**KIRKLEES METROPOLITAN COUNCIL
INVESTMENT & REGENERATION SERVICE**

**DELEGATED DECISION FOR APPLICATION FOR CERTIFICATE OF
LAWFUL DEVELOPMENT**

Reference no.: 2024/CL/90158/W

Description: Certificate of lawfulness for proposed hip to gable
extension

Dwg ref: 28DCC/P02 - Proposed Layouts : Scale 1:100/50 @ A3 : December 2023

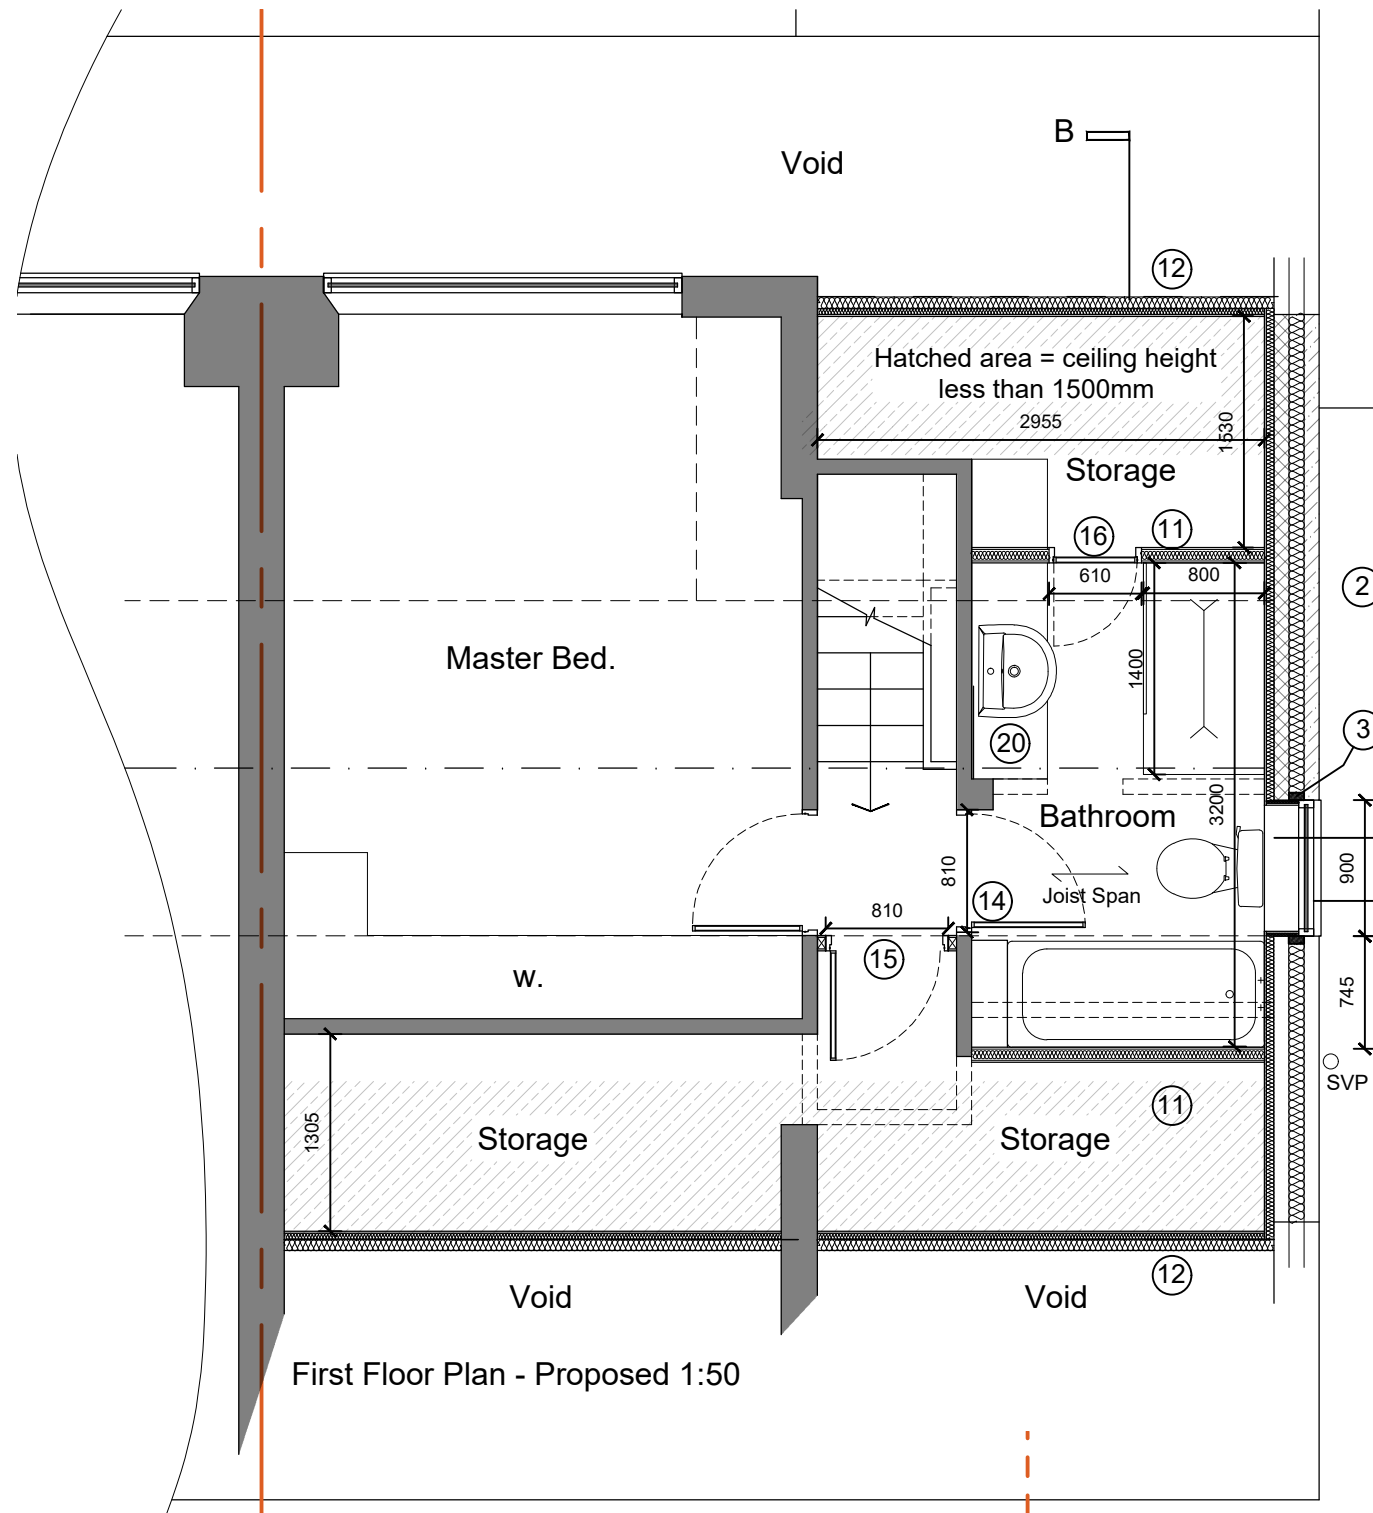
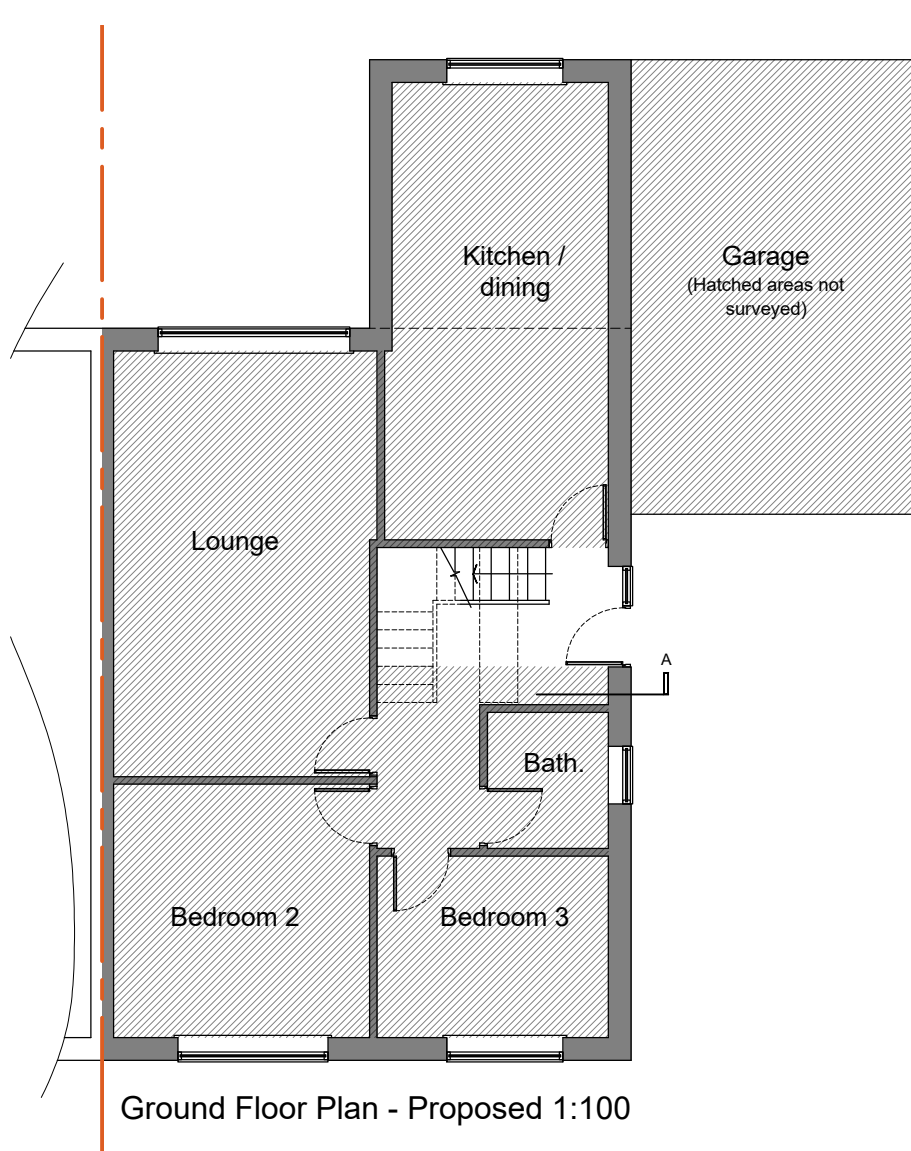
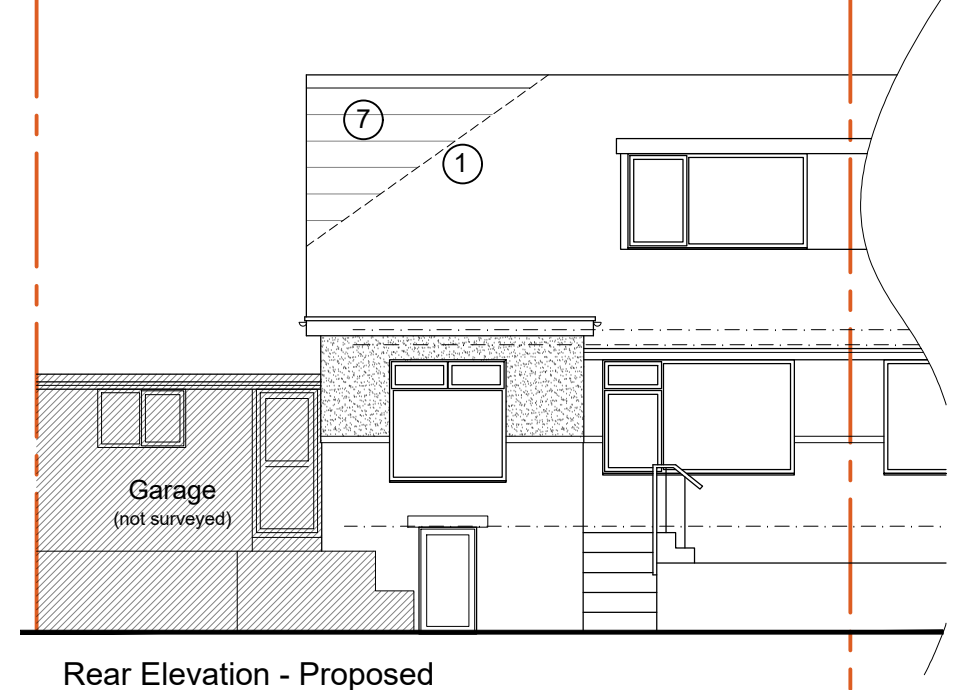
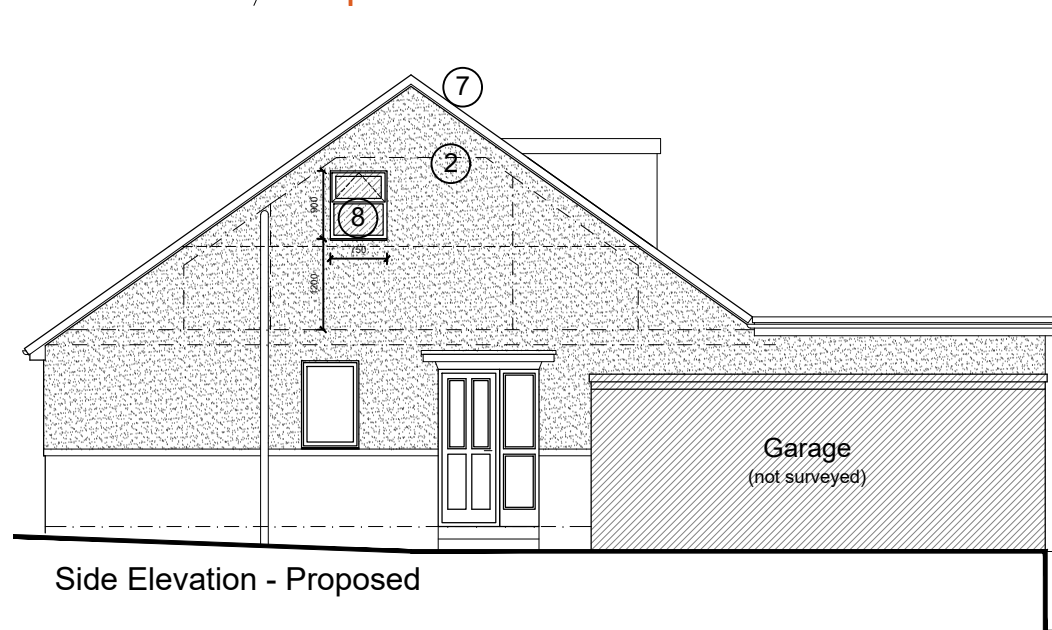
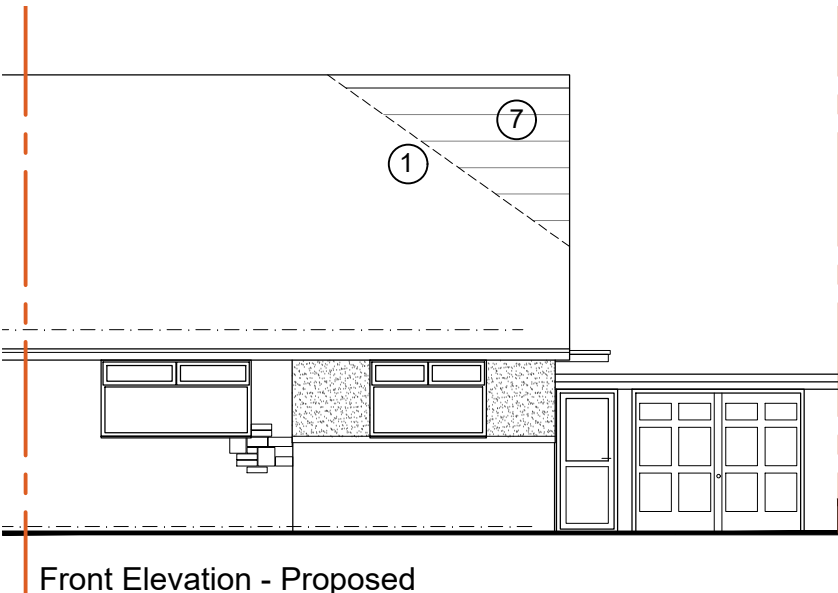
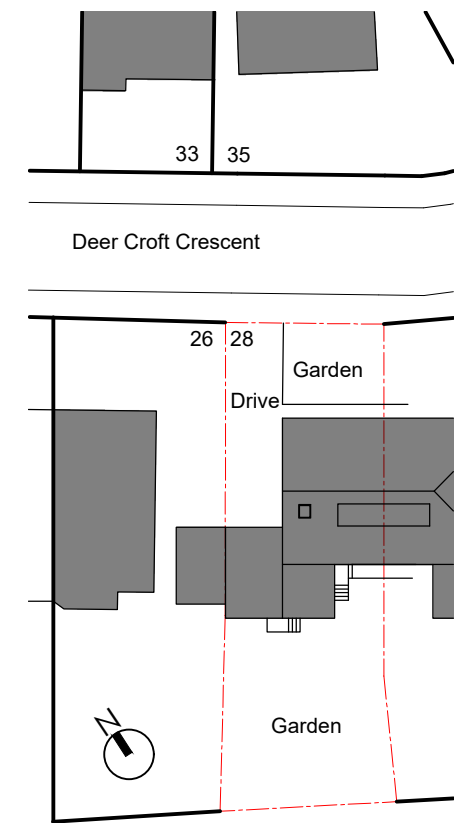
Comment As can be seen from the elevations, no part of the enlargement would exceed the height of the highest part of the existing roof.

eComment: The gable window will be obscurely glazed, as confirmed in an email dated 29th February 2024. The top opening casement is 1.7m from floor level.
